**Jonathan Rioux - Re: 28 Sewall St.**

**From:** Jonathan Rioux <JRIOUX@portlandmaine.gov>  
**To:** jaydensierra@yahoo.com  
**Sent:** Monday, July 15, 2013 12:59 PM  
**Subject:** 28 Sewall St.

Can you reply, the plan was missing stair details?

FRAME PLAN

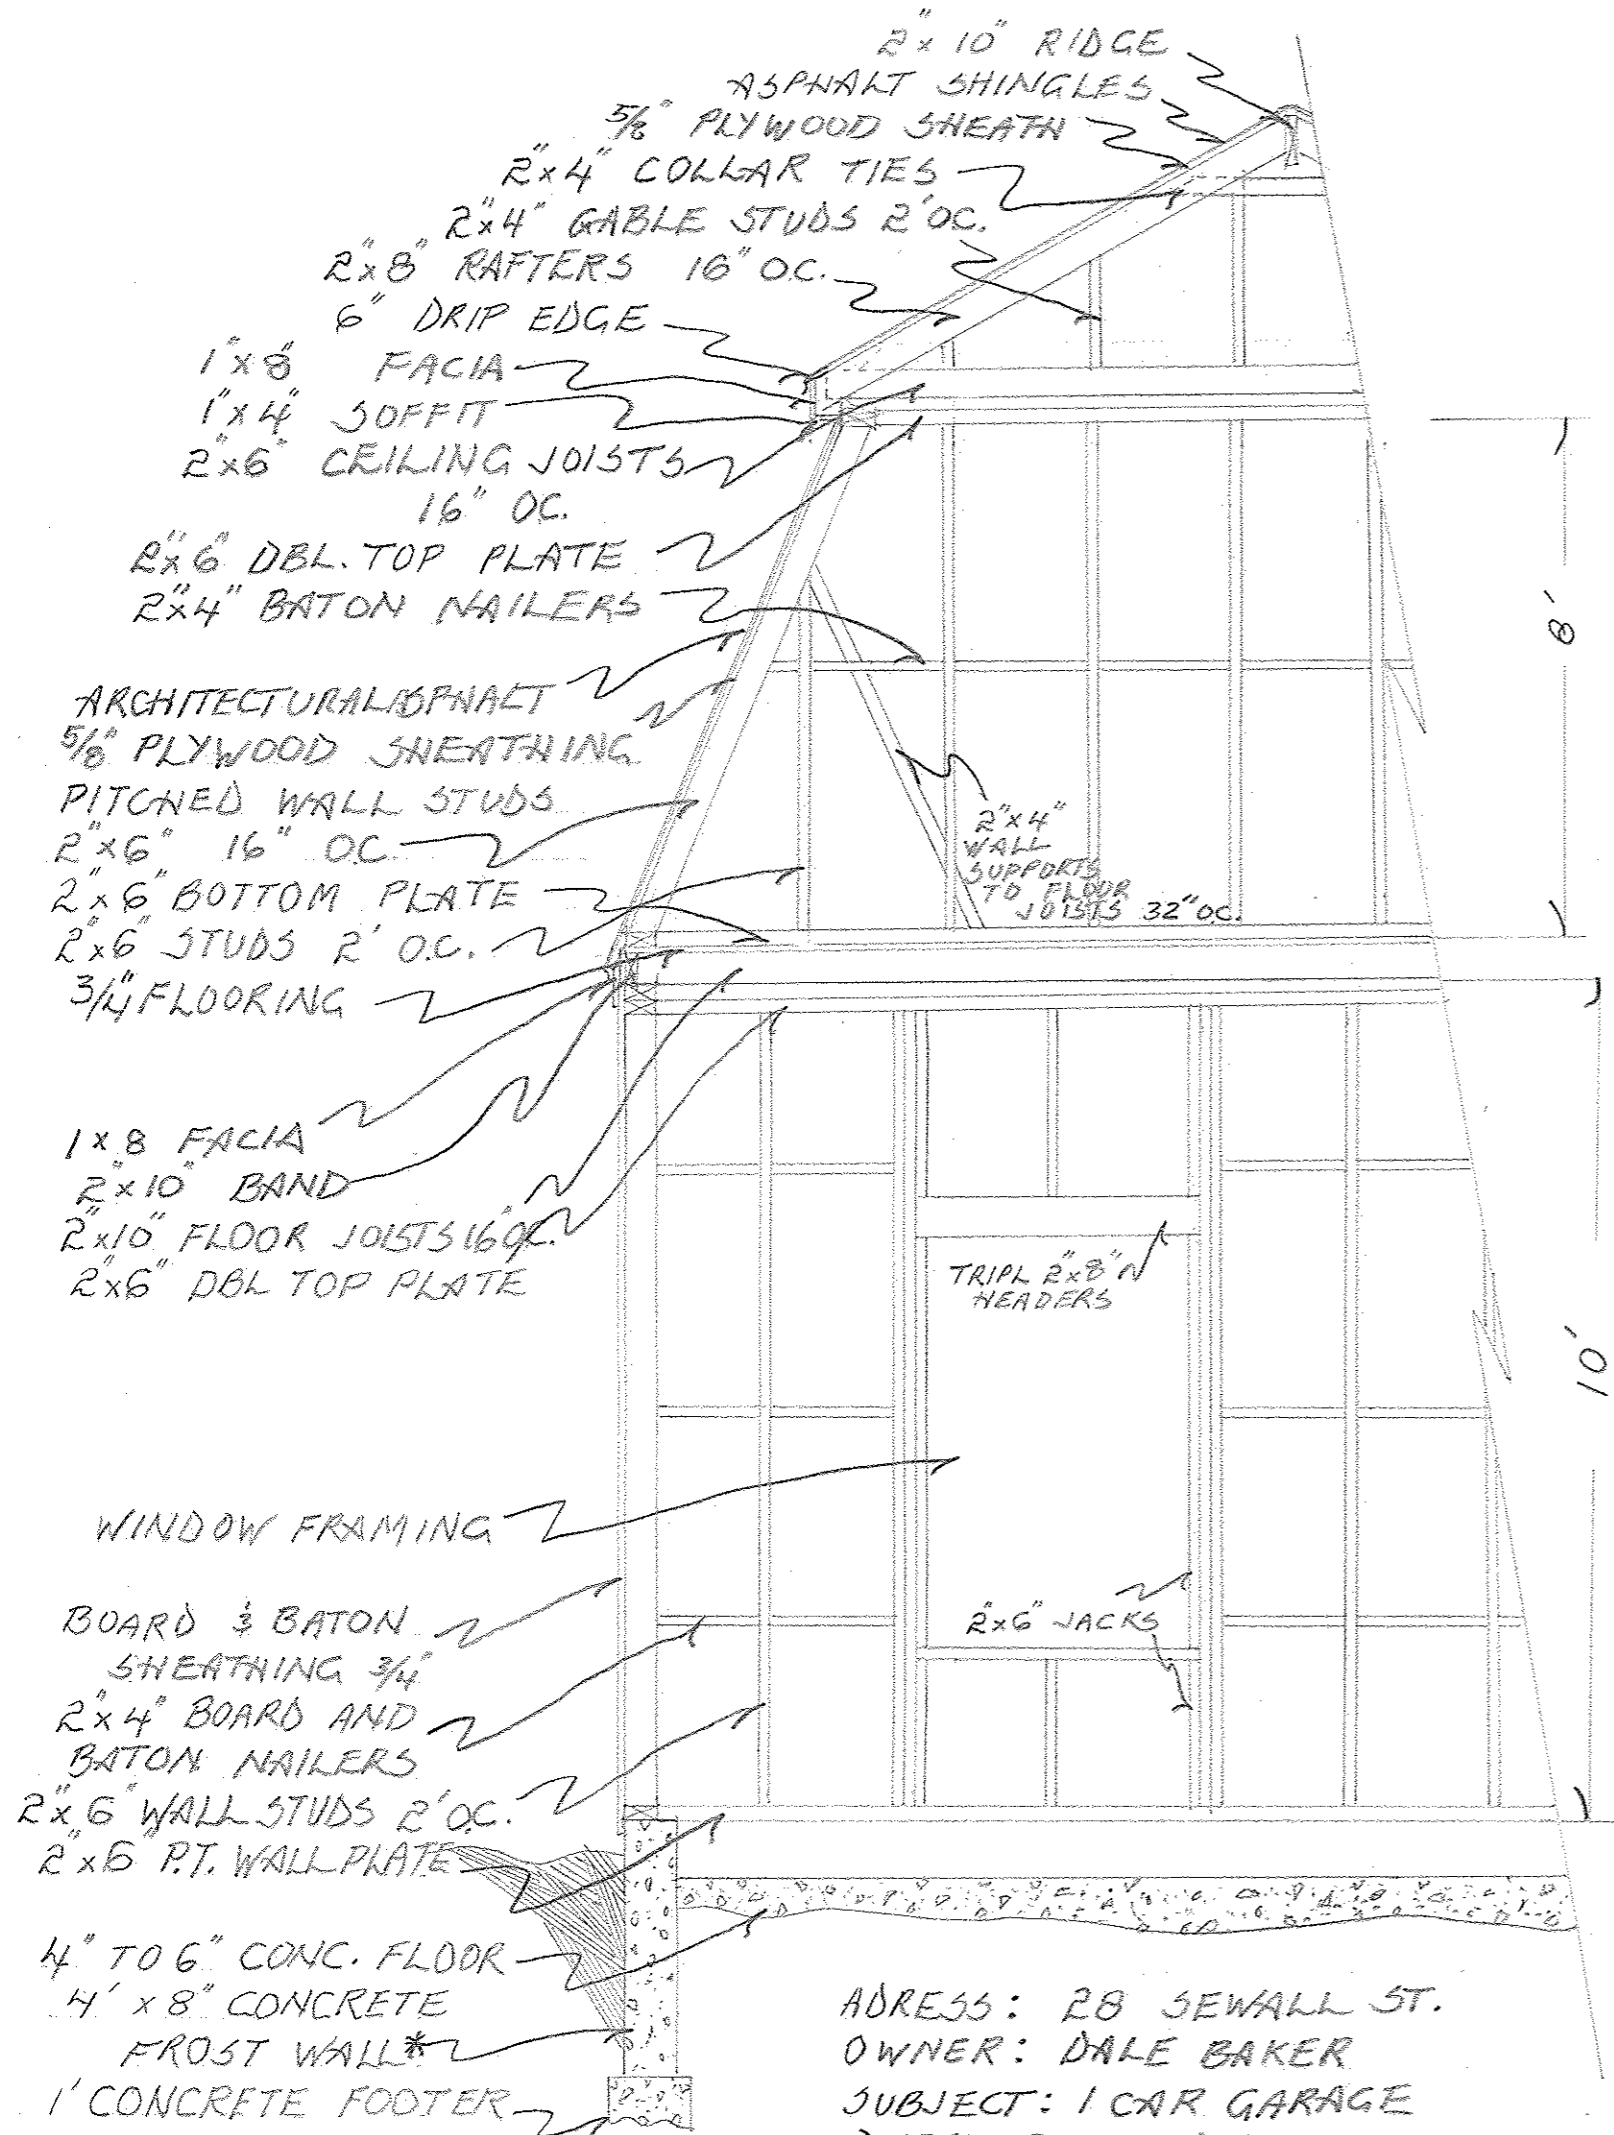
Not including the fire separation requirement (*if you choose to create a habitable space in the future*), below are some of our stair requirement(s) that were not indicated on you plan, see below:

- A graspable handrail (34-38 inches in height) shall be provided on at least one side of each continuous run of treads or flight with four or more risers. Fall protection (36 inches) from exterior decks may be required if floor joist are at or above thirty (30) inches from grade.

- Stairway headroom shall be not less than 6 feet 8 inches measured vertically from the sloped plane adjoining the tread nosing or from the floor surface of the landing or platform.

- The maximum riser height shall be 7 3/4 inches; the minimum tread depth shall be 10 inches.
- R312.3 Opening limitations. Required *guards* shall not have openings from the walking surface to the required *guard* height which allow passage of a sphere 4 inches in diameter.

- R311.7.1 Width. Stairways shall not be less than 36 inches in clear width at all points above the permitted handrail height and below the required headroom height. Handrails shall not project more than 4.5 inches on either side of the stairway and the minimum clear width of the stairway at and below the handrail height, including treads and landings, shall not be less than 31 1/2 inches where a handrail is installed on one side and 27 inches where handrails are provided on both sides.
